CITY OF ALBUQUERQUE

May 4, 2023

Re: ALLSUP'S Convenience Store
9501 Gibson Blvd. SW
Traffic Circulation Layout
Engineer's/Architect's Stamp XX-XX-XX (M09-D034)

Based upon the information provided in your submittal received 04-12-23, the above referenced plan cannot be approved for Building Permit until the following comments are addressed:

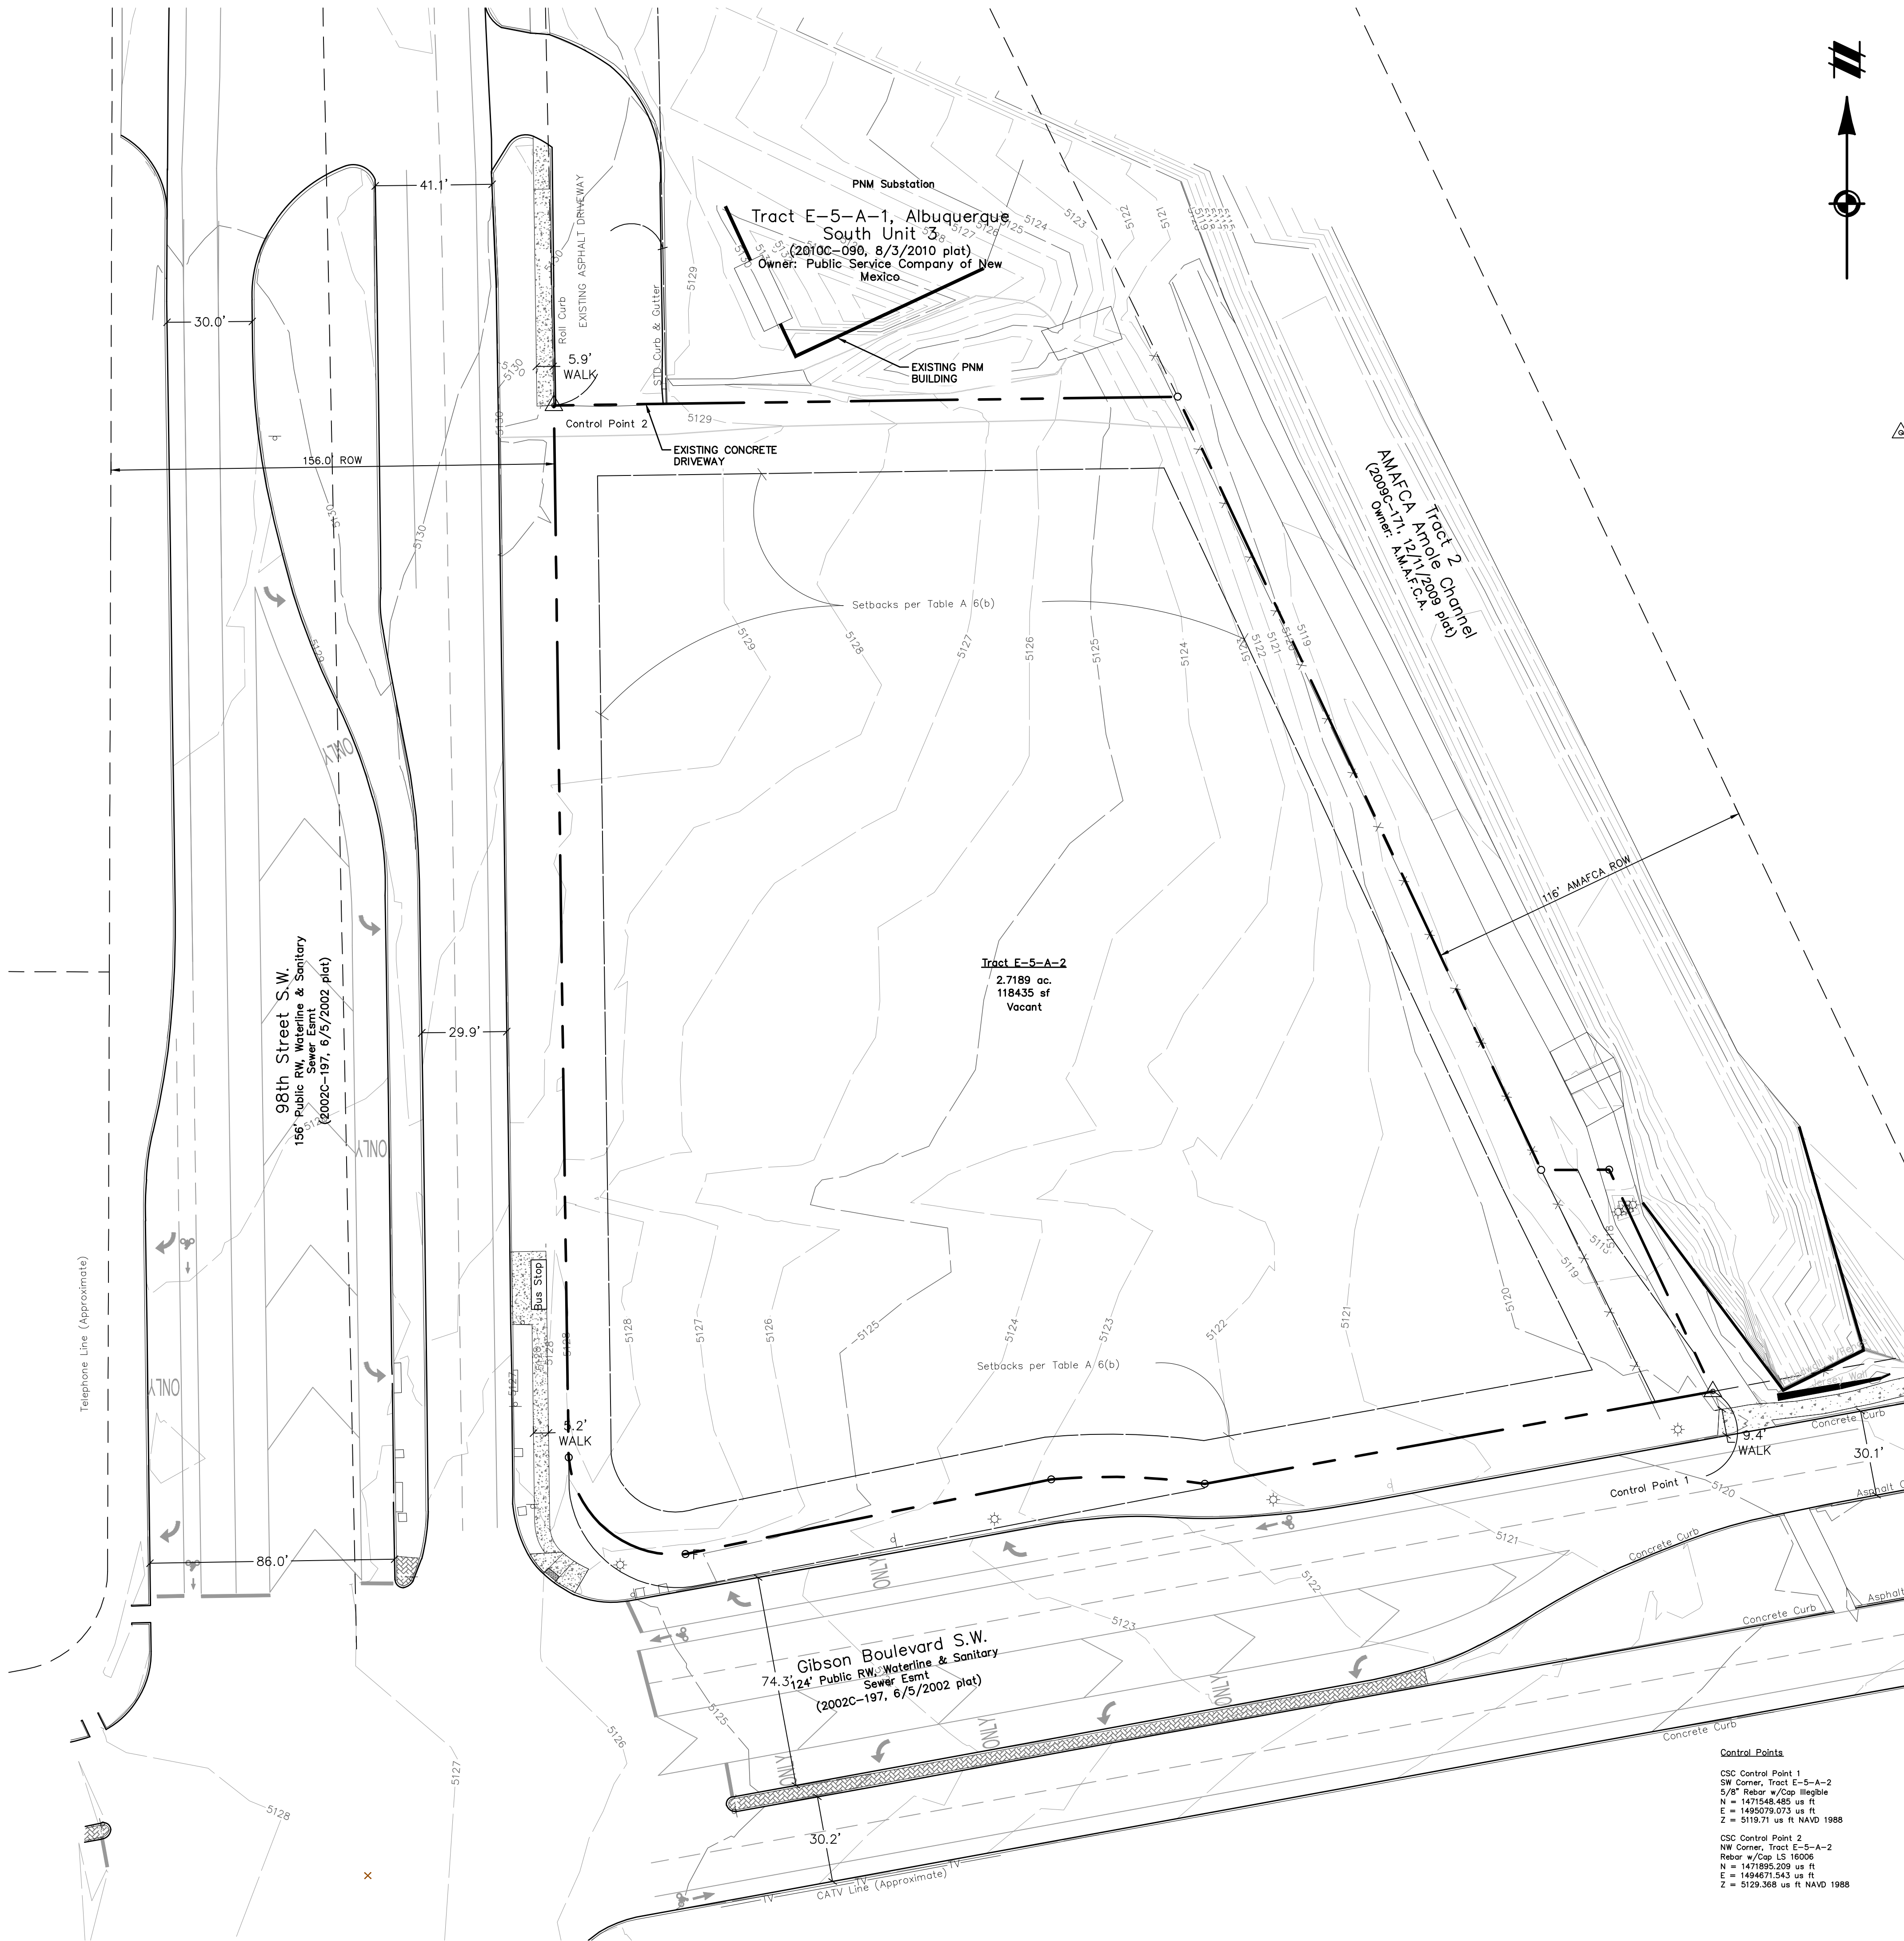
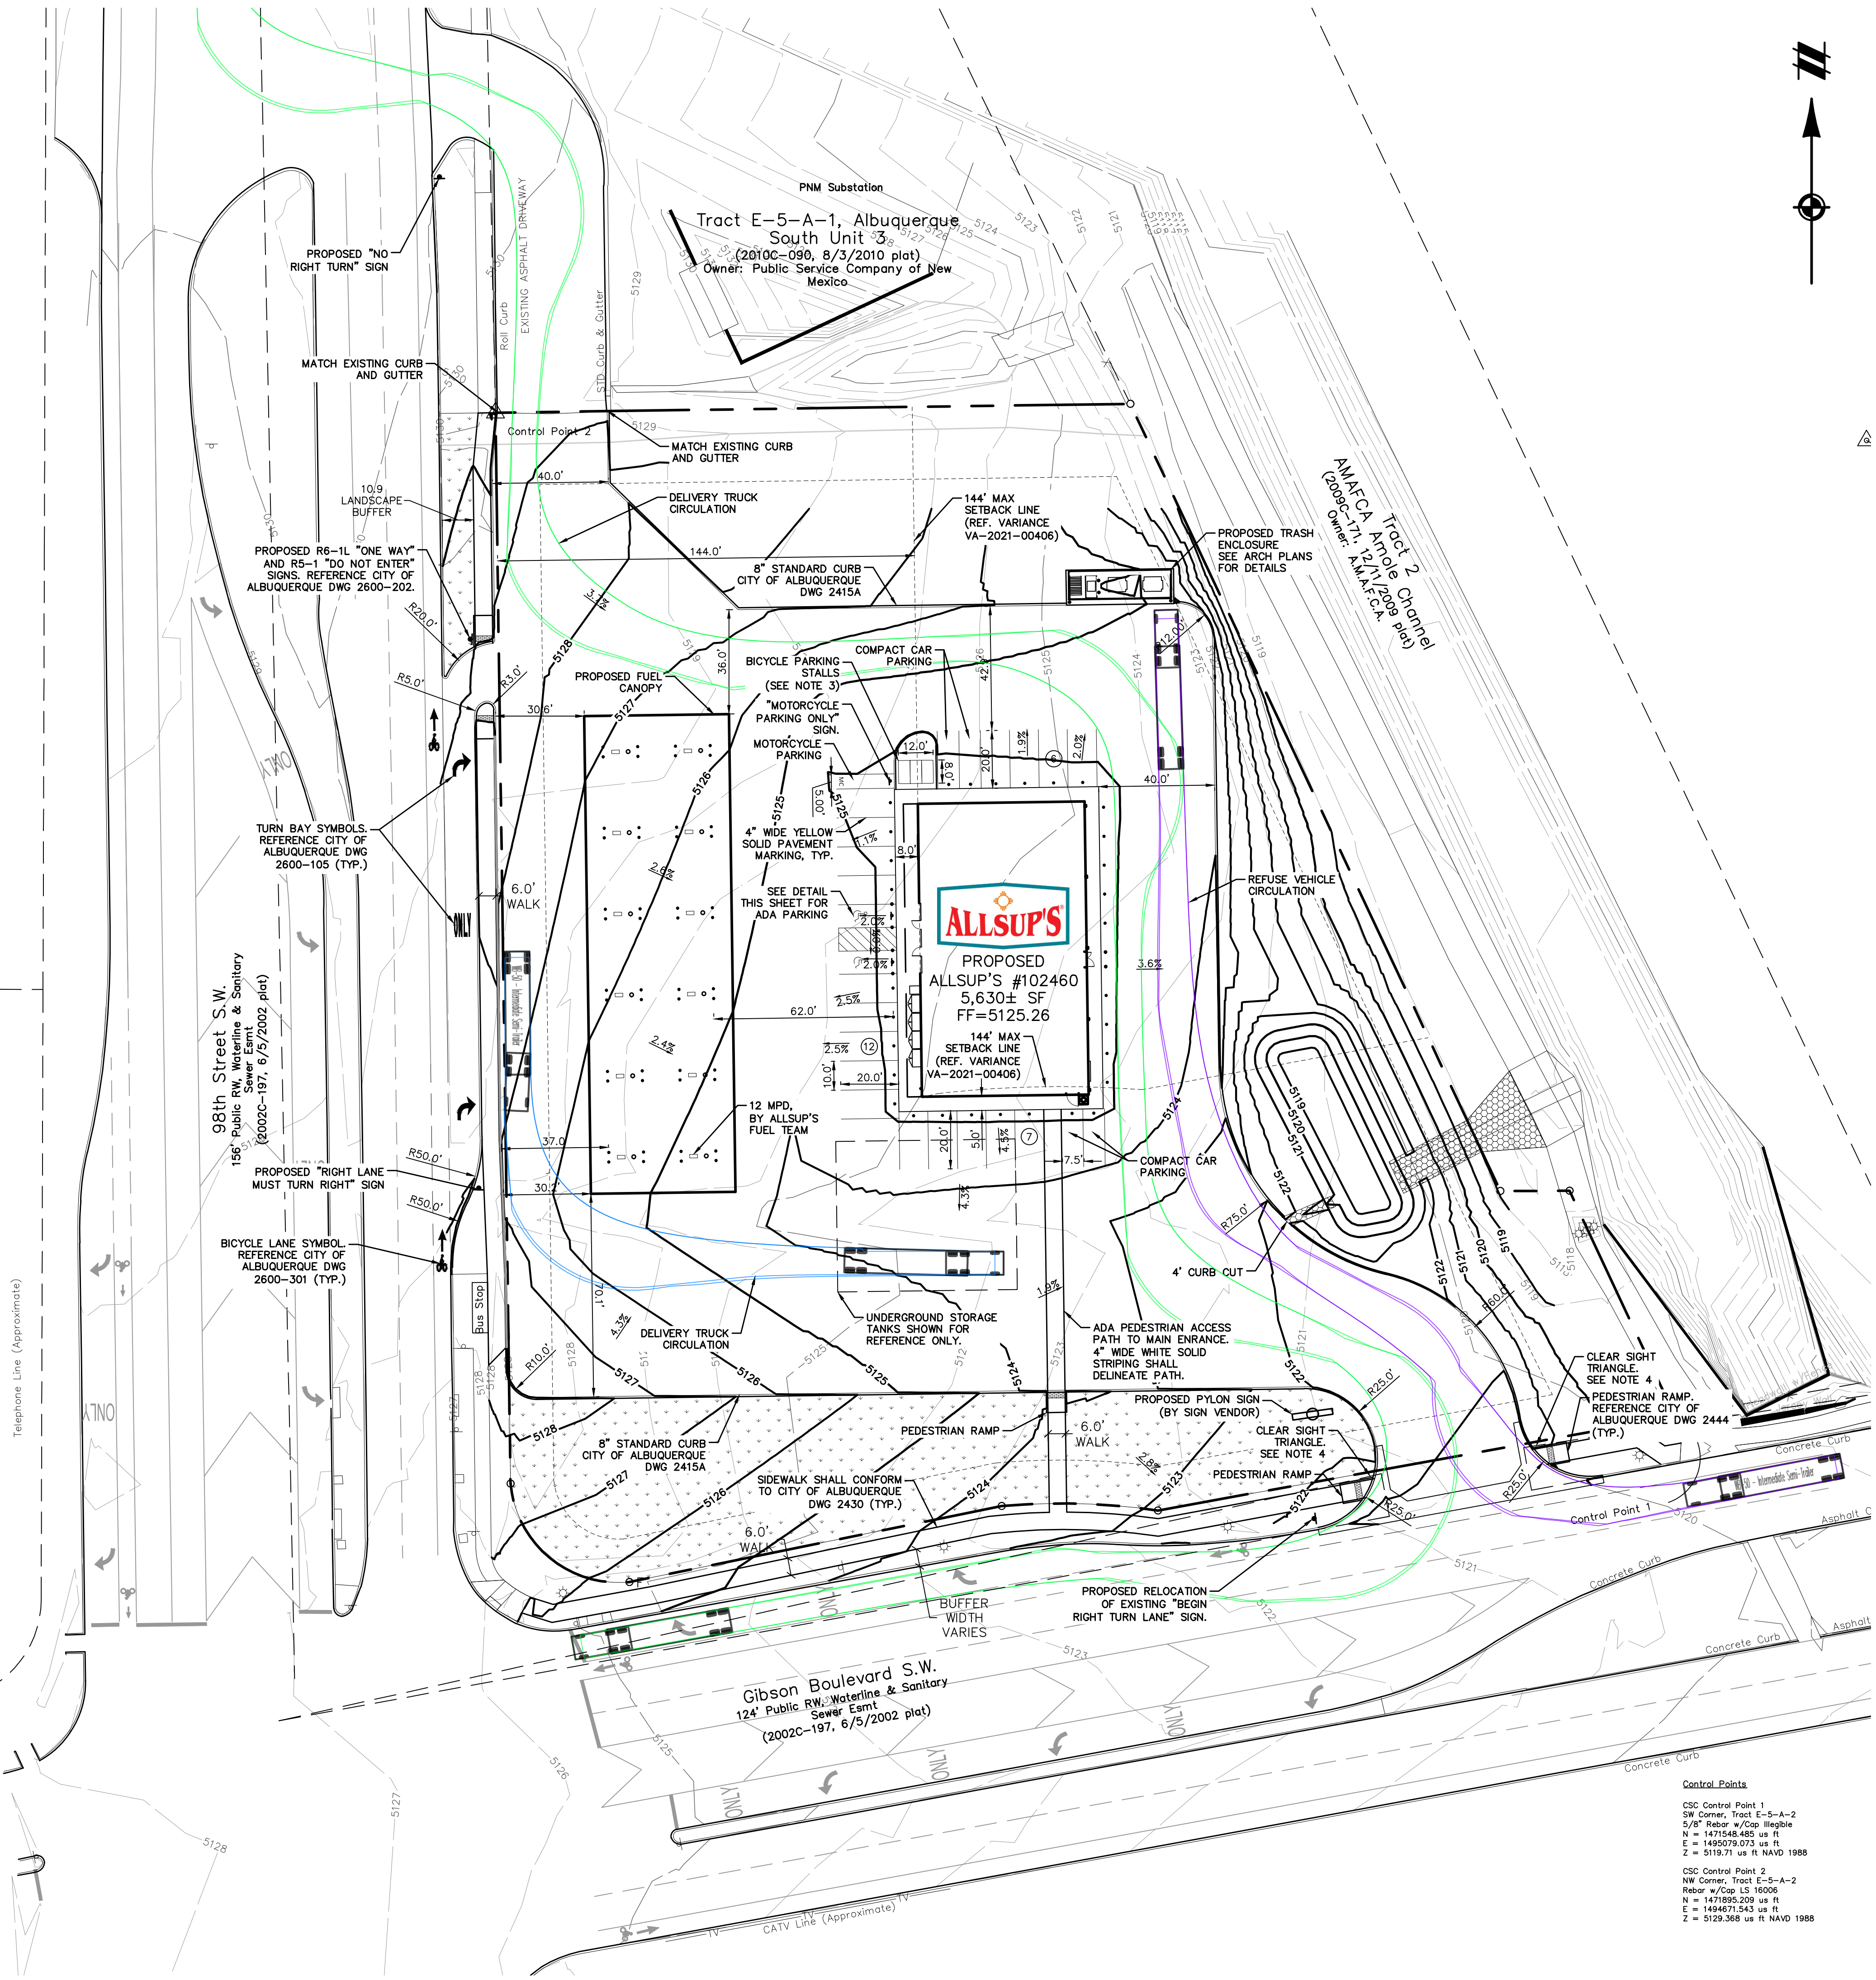
1. Please show a vicinity map showing the location of the development in relation to streets and well-known landmarks.
2. List the number of Motorcycle and Bicycle parking spaces required by the IDO.

3. The traffic circulation layout must be stamped, signed, and dated by an engineer or architect licensed in the state of New Mexico.
4. Identify all existing access easements and rights of way width dimensions.

5. Please provide approved DRC site plans showing the approval for the proposed Right Turn Lane off Gibson.
6. Please show on the site plan the buffer width off Gibson and 98th St.

7. Please provide design details for both proposed site accesses.
8. Provide details for all the proposed ADA ramps.
9. Please reference 2430 COA std dwg for the proposed sidewalk.

10. The ADA accessible parking sign must have the required language per 66-7-352.4C NMSA 1978 **"Violators Are Subject to a Fine and/or Towing."** Please call out detail and location of signs.

11. The ADA access aisles shall have the words **"NO PARKING"** in capital letters, each of which shall be at least one foot high and at least two inches wide, placed at the rear of the parking space so as to be close to where an adjacent vehicle's rear tire would be placed. (66-1-4.1. B NMSA 1978)

12. Motorcycle parking spaces shall be designated by its own conspicuously posted upright sign, either free-standing or wall mounted per the zoning code.

13. The pavement marking "MC" should be shown in the opposite direction for motorcycles entering the parking space.
14. All bicycle racks shall be designed according to the following guidelines:

18. Per the IDO, a 6 ft. wide ADA accessible pedestrian pathway is required from the public sidewalk to the building entrances. Please clearly show this pathway and provide details.

19. Per DPM, a 6 ft. wide ADA accessible pedestrian pathway is required from the ADA parking stall access aisles to the building entrances. Please clearly show this pathway and provide details.

20. ADA accessible pedestrian pathway should not be placed behind parking space or adjacent to a vehicular way. Vehicle and pedestrian/wheel chair conflicts should be avoided as much as possible.

21. Refuse vehicle maneuvering shall be contained on-site. The refuse vehicle shall not back into the public right of way.; provide a copy of refuse approval.

22. Please provide "One Way" and "Do Not Enter" signage and pavement markings for the One-Way site access off 98th St. Please show detail and location of posted signs and striping.

23. Please provide a sight distance exhibit
 24. Show the clear sight triangle and add the following note to the plan: "Landscaping and signage will not interfere with clear sight requirements. Therefore, signs, walls, trees, and shrubbery between 3 and 8 feet tall (as measured from the gutter pan) will not be acceptable in the clear sight triangle.

27. Work within the public right of way requires a work order with DRC approved plans.
 28. Please add a note on the plan stating "All improvements located in the Right of Way must be included on the work order."

29. Add a note stating "All broken or cracked sidewalk must be replaced with sidewalk and curb & gutter." A build note must be provided referring to the appropriate City Standard drawing.
30. Please provide a letter of response for all comments given.
31. Traffic Studies: See the Traffic Impact Study (TIS) thresholds. In general, a minimum combination of 100 vehicles entering and exiting in the peak hour warrants a Traffic Impact Study. Visit with Traffic Engineer for determination, and fill out a TIS Form that states whether one is warranted. In some cases, a trip generation may be requested for determination (**Contact Matt Grush: mgrush@cabq.gov**).
